REFUSAL OF PLANNING PERMISSION

**APPLICATION NO:** 3/2022/1039

**DEVELOPMENT PROPOSED:** Proposed construction of two new detached dwellings with associated access and garden areas. Resubmission of 3/2021/1263.

**AT:** Land adjacent to 115 Kemple View Clitheroe BB7 2QJ

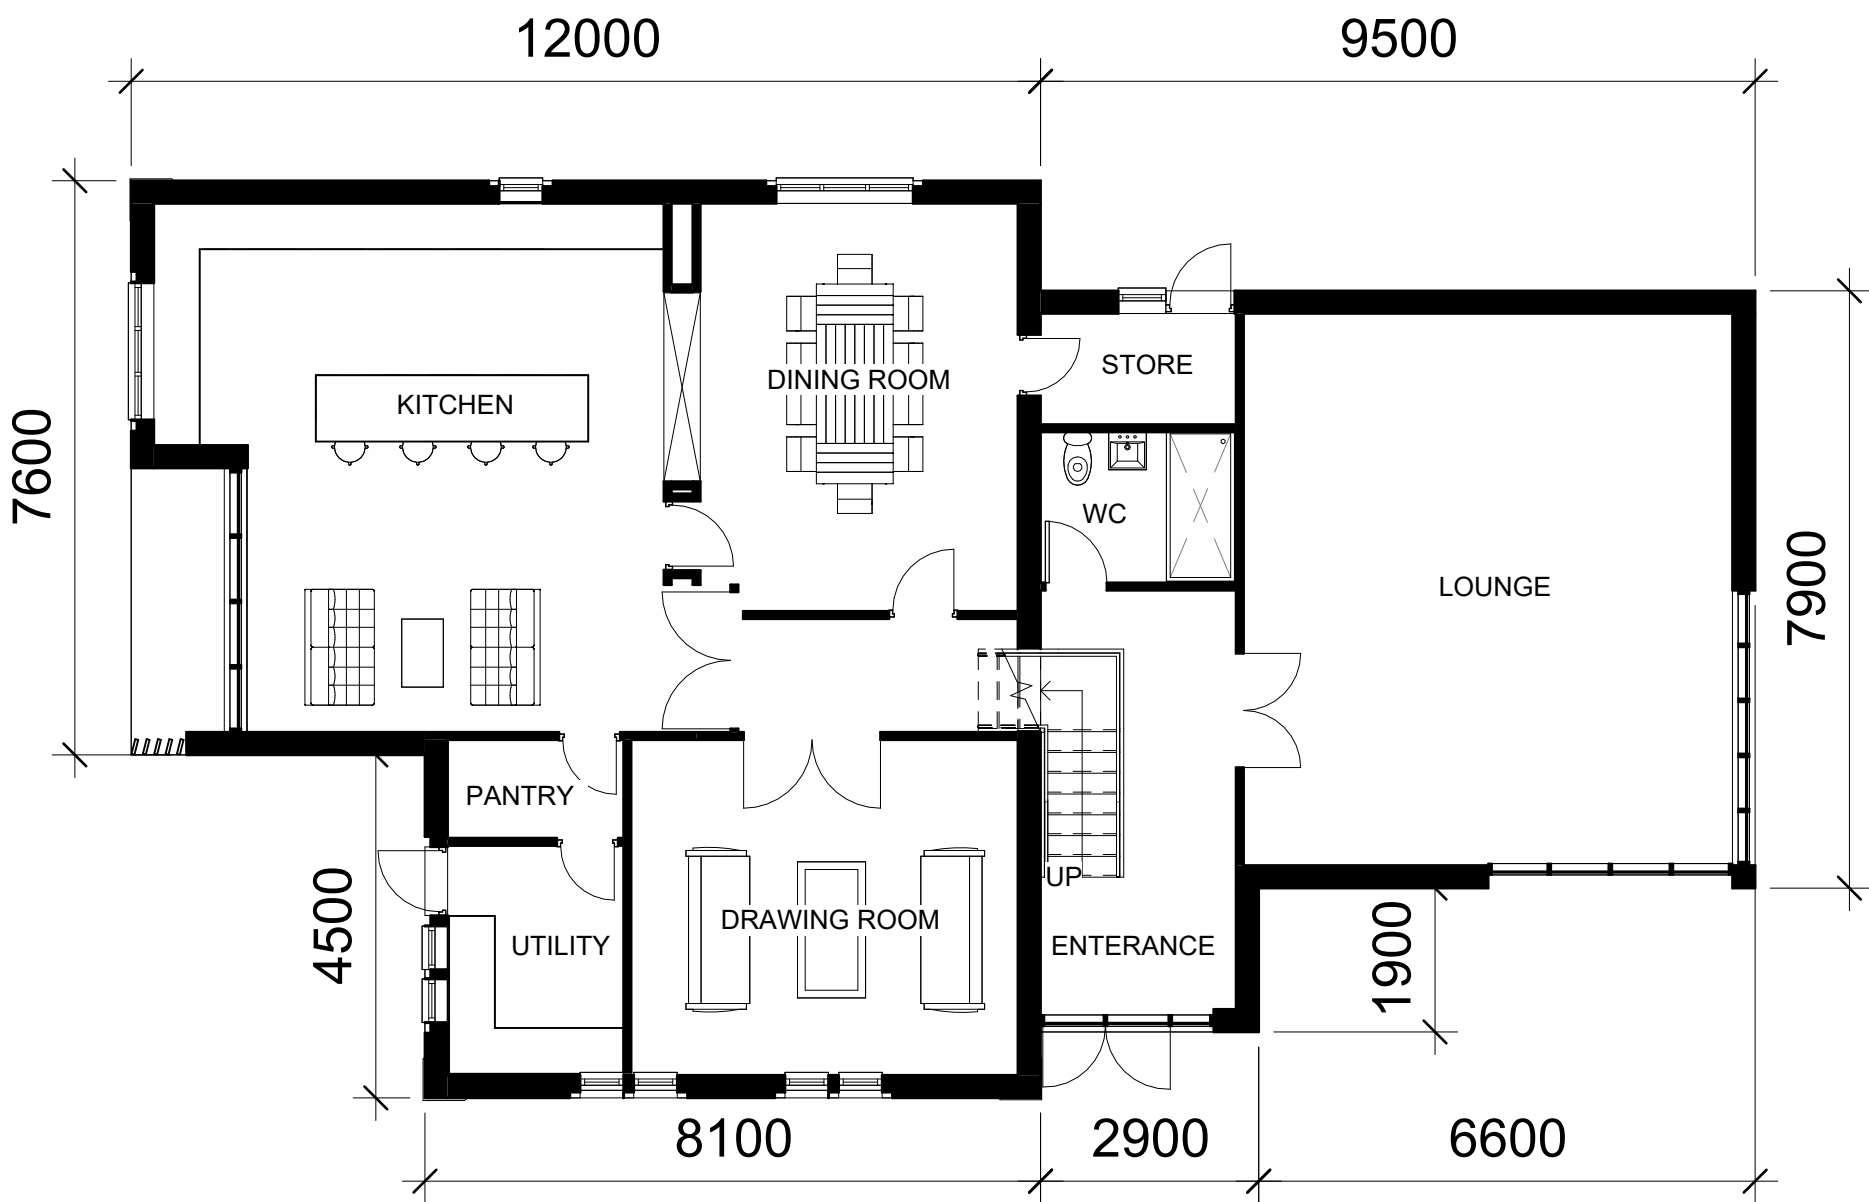
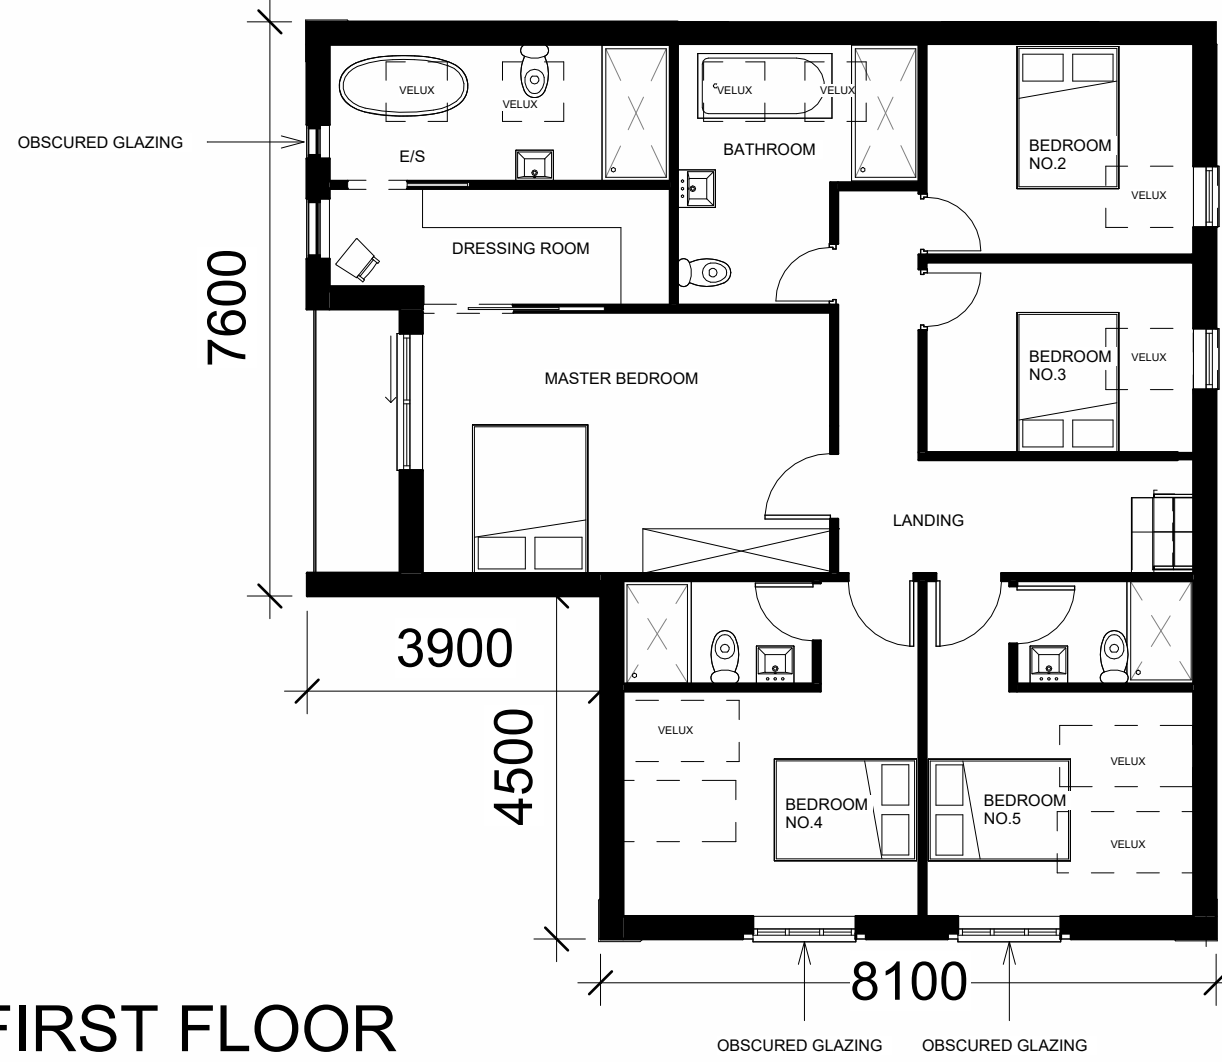
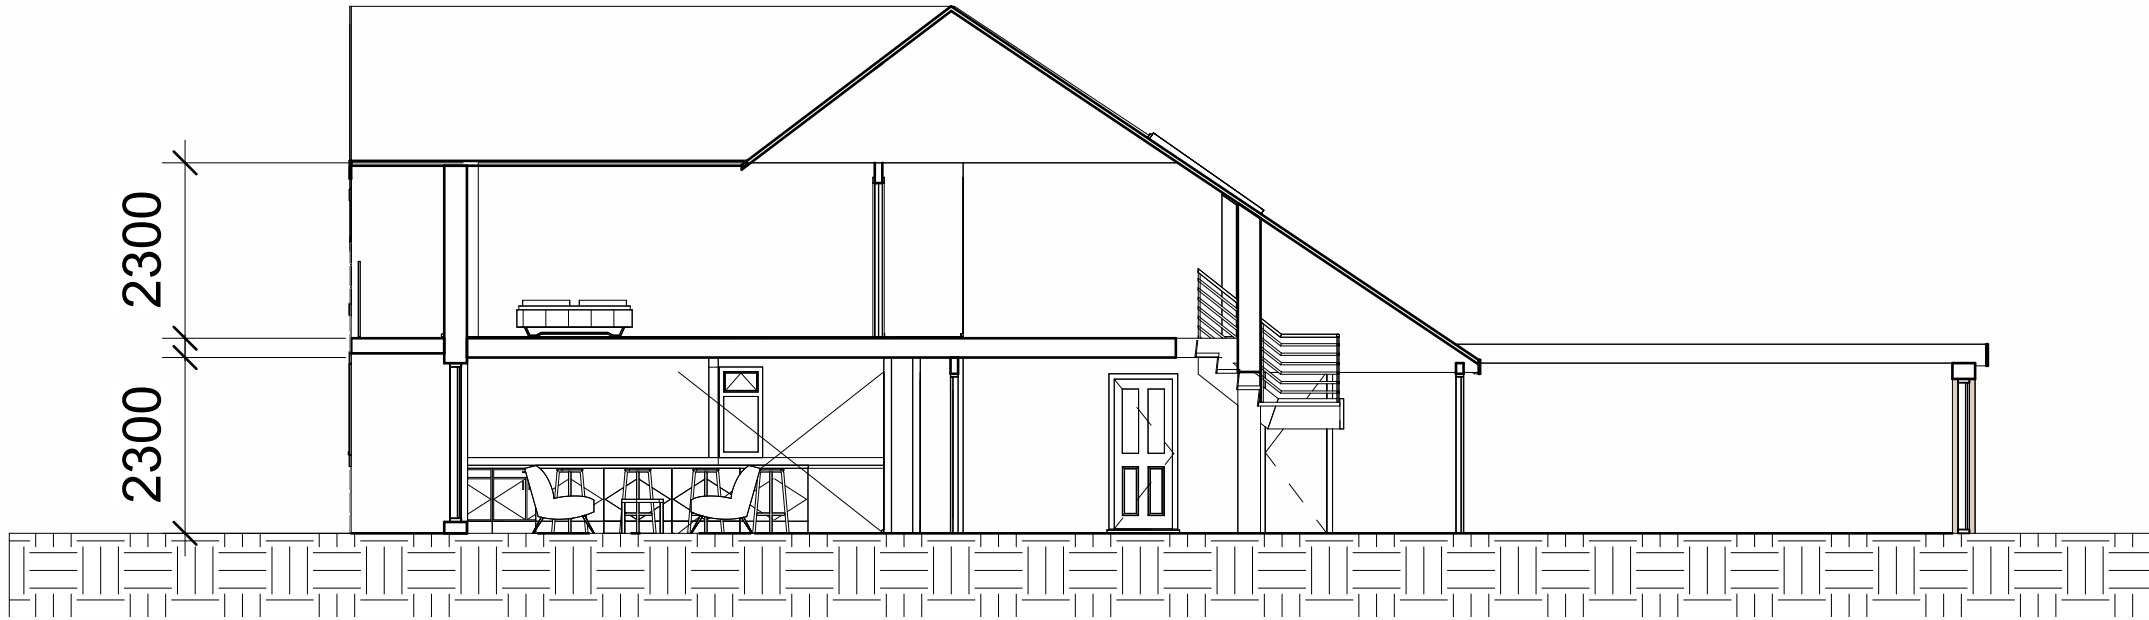
- 1 The proposal is considered contrary to Policy DMG1 of the Ribble Valley Core Strategy insofar that the proximity, scale and orientation of 'Building 2' would significantly undermine and compromise the residential amenities of the occupiers of 115 Kemple View by virtue of a direct unsympathetic overbearing relationship.

1 PROPOSED SITE PLAN 1
1 : 200

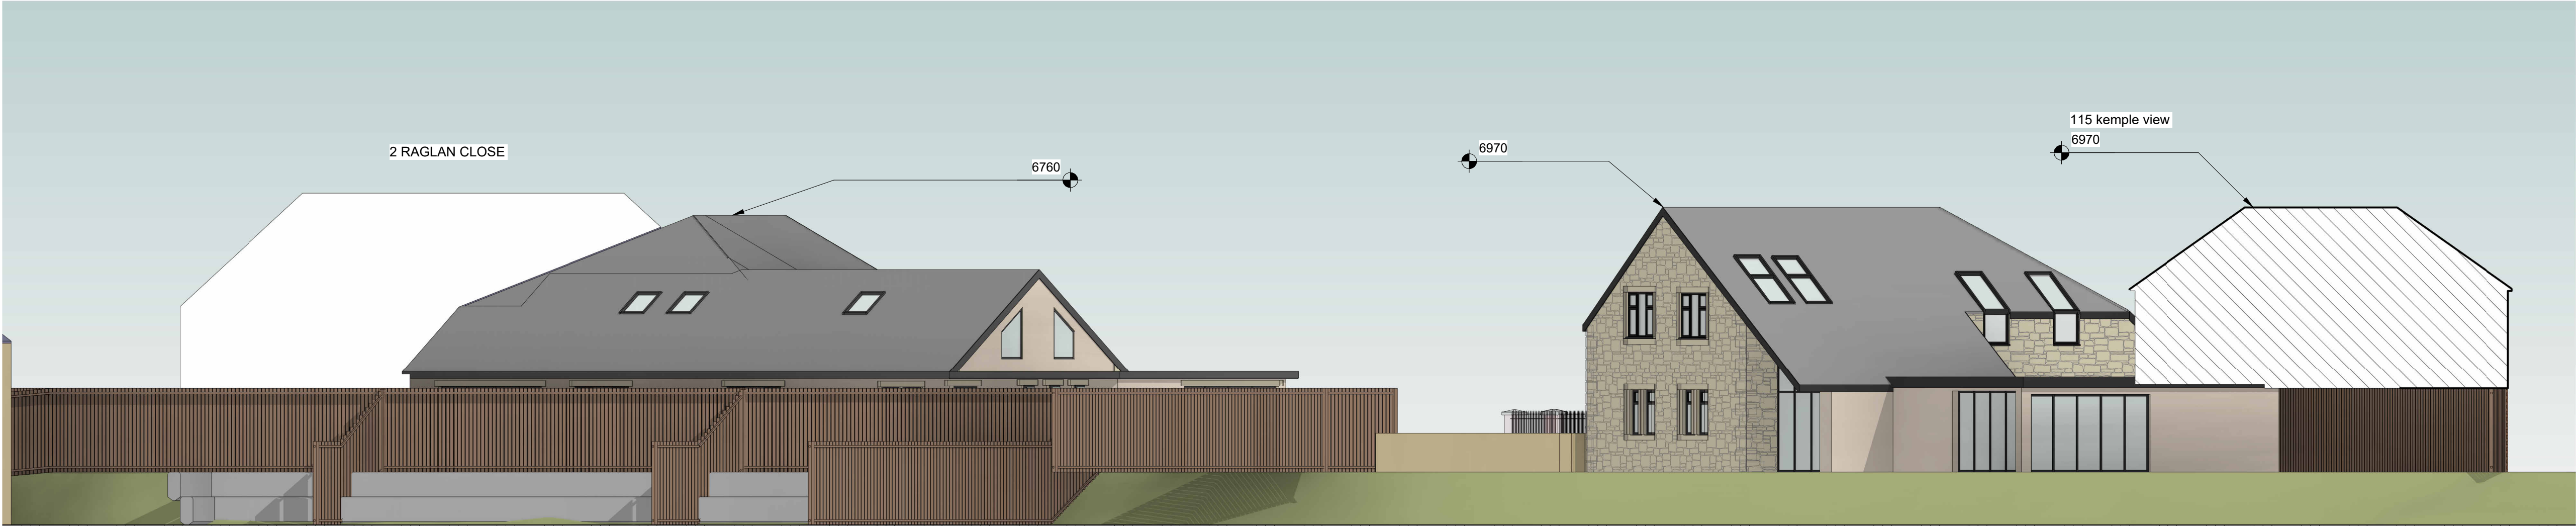
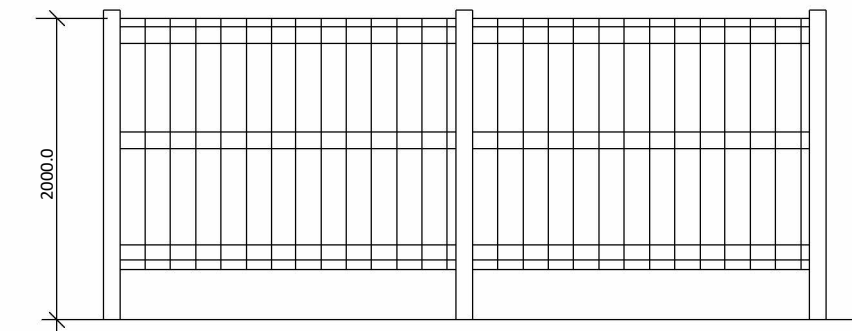
- 2 The proposal is considered contrary to Policy DMG1 of the Ribble Valley Core Strategy in that the proximity, scale and orientation of 'Building 1' would significantly undermine and compromise the residential amenities of the occupiers of residential dwellings to the south-west by virtue of an overbearing relationship, exacerbated by the differing topographies between that of the application site and garden areas/land-levels associated with the existing affected dwellings.

- 3 The proposal is considered contrary to Policy DMG1 of the Ribble Valley Core Strategy and Paragraphs 135 and 139 of the National Planning Policy Framework insofar that approval of the proposal would result in the introduction of an anomalous and discordant pattern and form of development, that by virtue of the scale of the proposed dwellings, their inherent footprints and site configuration, would fail to respond positively to the inherent pattern and scale of adjacent built-form being of significant detriment to the character and visual amenities of the area.
